Please ask for: Nicola Moore
Email: nicola.moore@arun.gov.uk
Telephone: Ext 37944
Our Ref: FG/46/21/PL
Your Ref:
Date: 22nd March 2021

Application for Planning Permission

Development: Development of 1 2 bed house set over 2 floors, with the first floor being partially contained within the roof, along with associated parking & amenity spaces. This site is within CIL Zone 4 and is CIL liable as new dwelling.
Location: Land Between 11a The Grove And 30 Brook Lane Ferring

Drawing Title 028_04 Proposed Roof Plan Land between 11A The Grove and 30 Brook Lane, Ferring					
Completion date 17/03/2021					
Drawn by Guy Rochez ARB					
Scale: 1:100@A3					
Print Size: A3					
Notes:

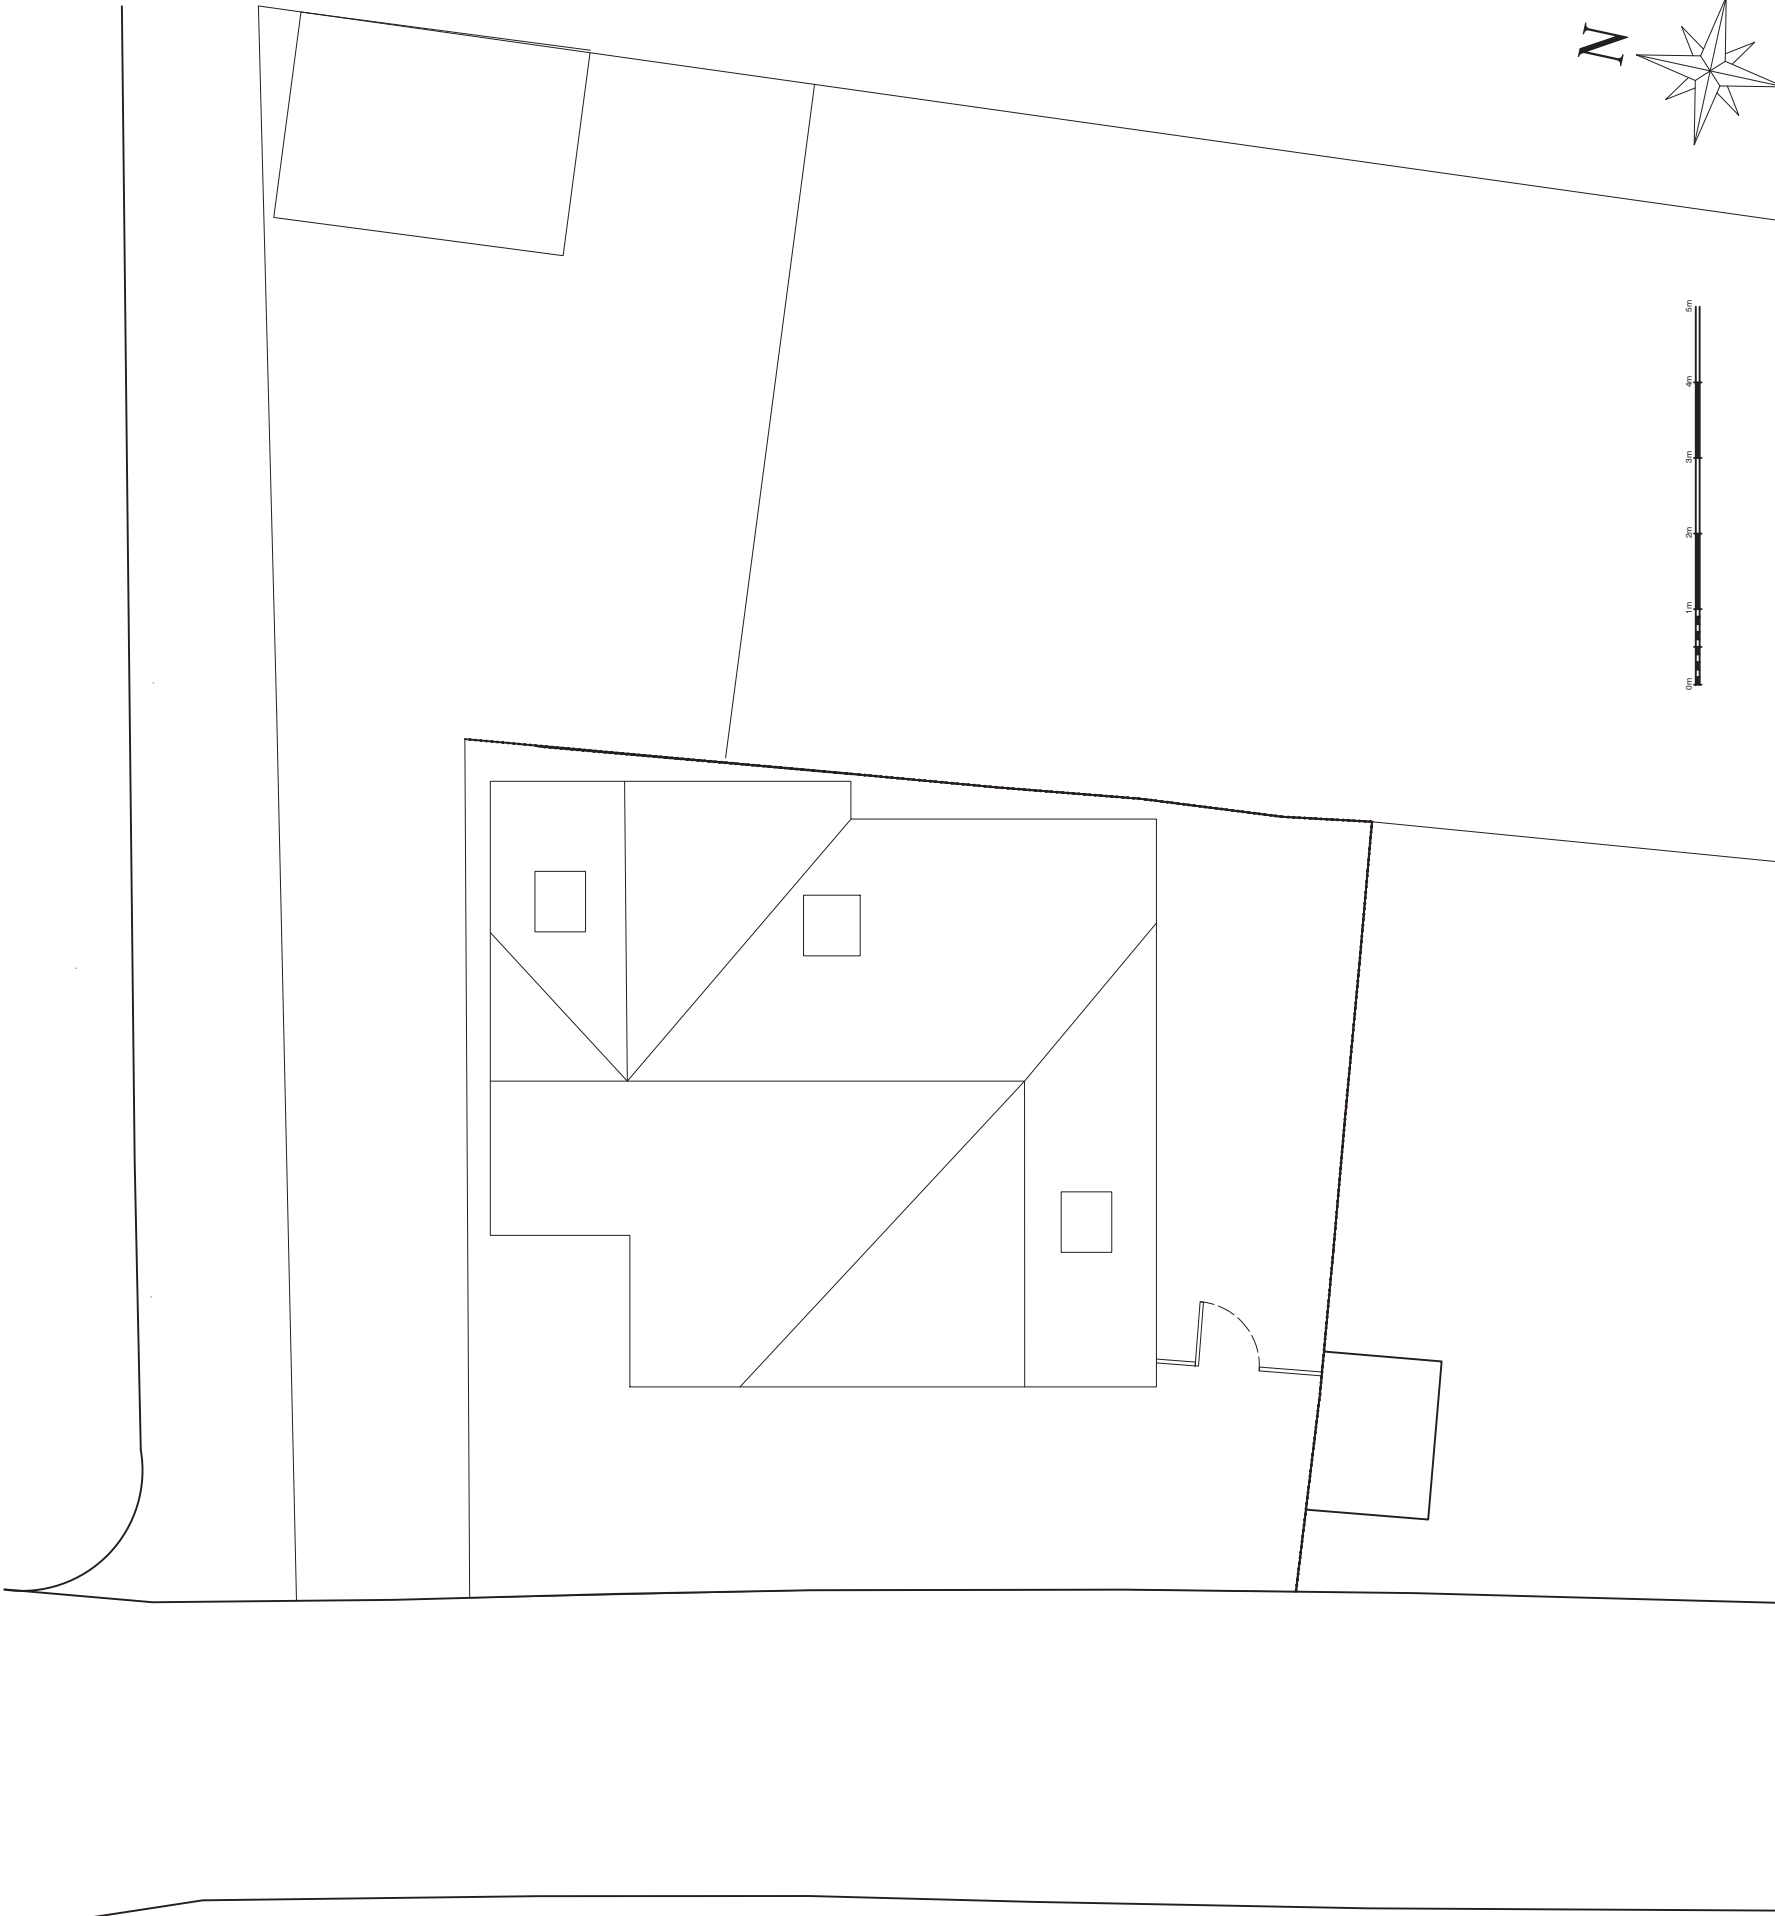
Roof Plan

The submitted Roof plan does not show the proposed roof lights. Please amend accordingly and re submit.
